ADC PARKS & GREENSPACE ARBORICULTURE

PLANNING APPLICATION: AW/48/15/HH

ADDRESS: 16 Barrack Lane Aldwick PO21 4BZ

BRIEF DESCRIPTION: Rear 1st floor extension, rear single storey extension & boundary wall & gates.

PROPOSED BOUNDARY WALL AT 16, BARRACK LANE, ALDWICK FOR MR. & MRS. T. KEET.

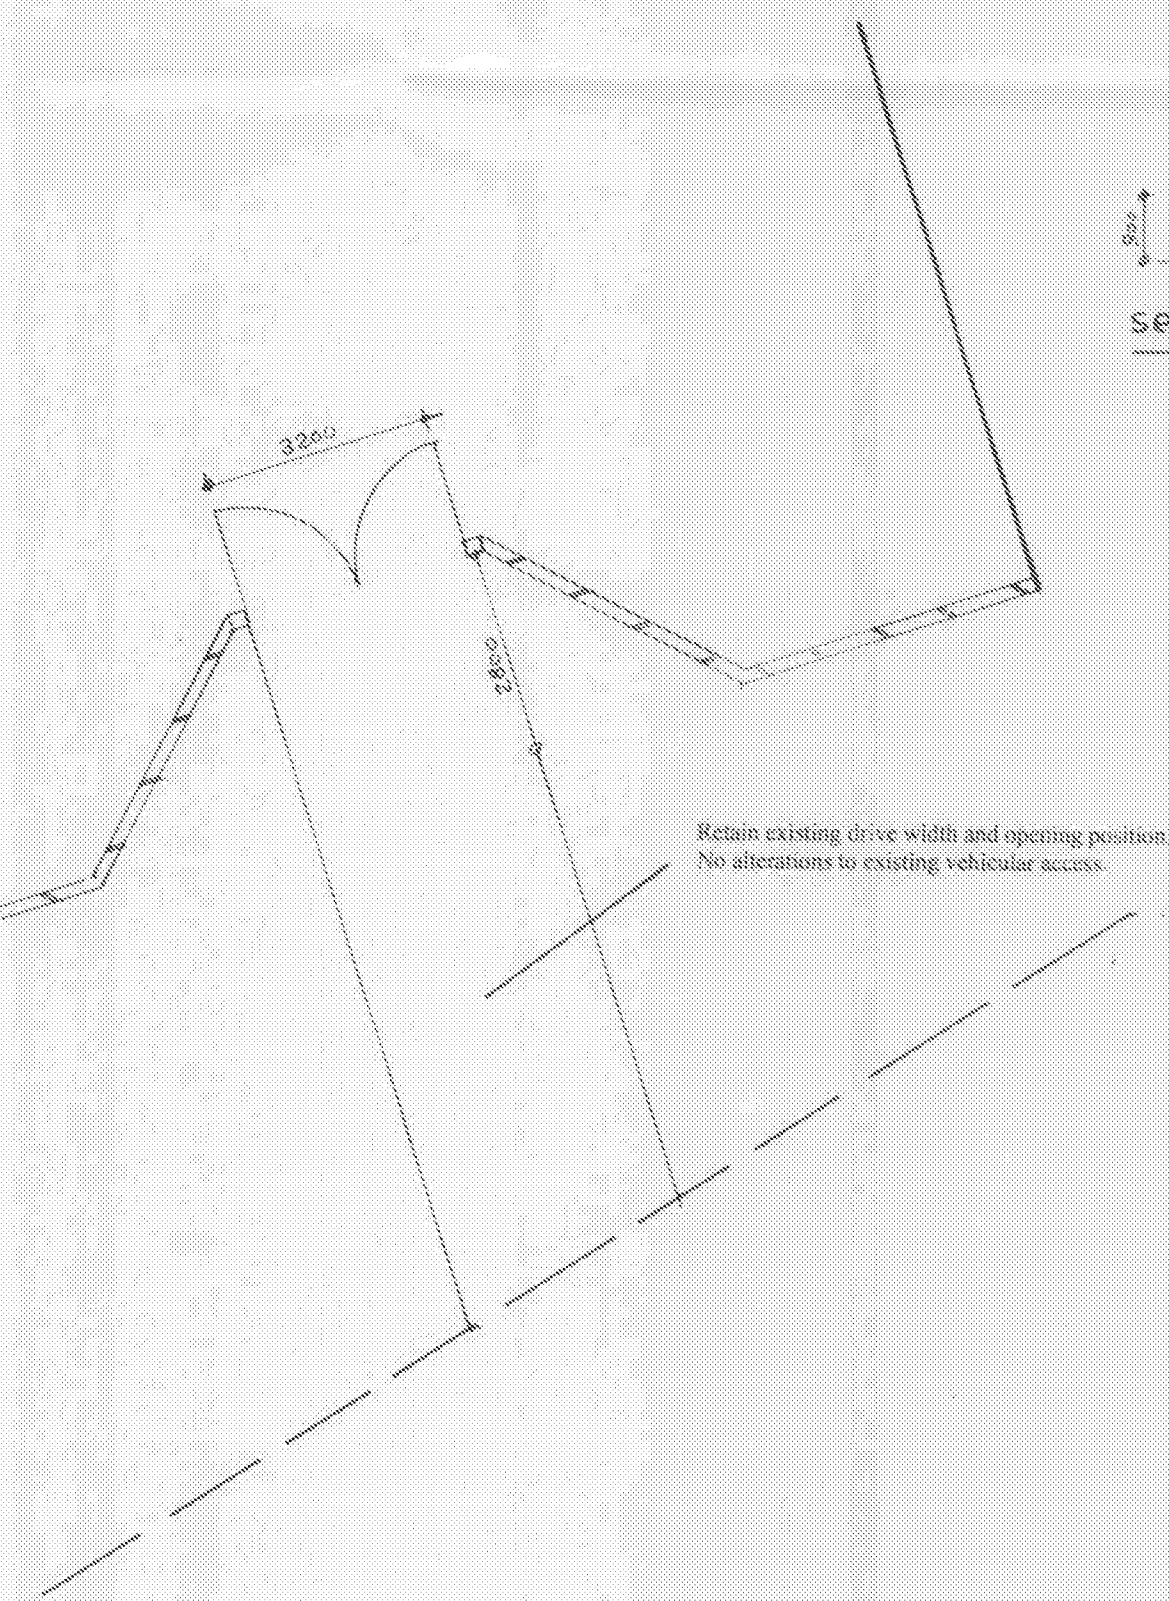
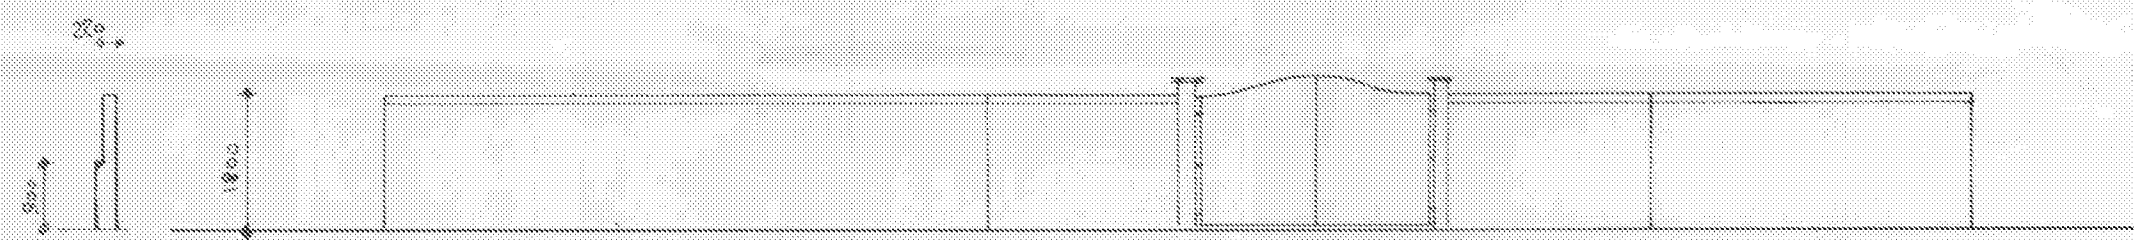
- From the submitted plans, there appears to be a possible conflict between the proposed construction process, and the respective RPA's of the established trees on site. This is most apparent for the proposed boundary wall, which from the submitted plans would appear to intrude into the RPA's of the established trees in the along the front boundary of the site.

- To properly assess this application for its tree protection, the previously mentioned information must be submitted.
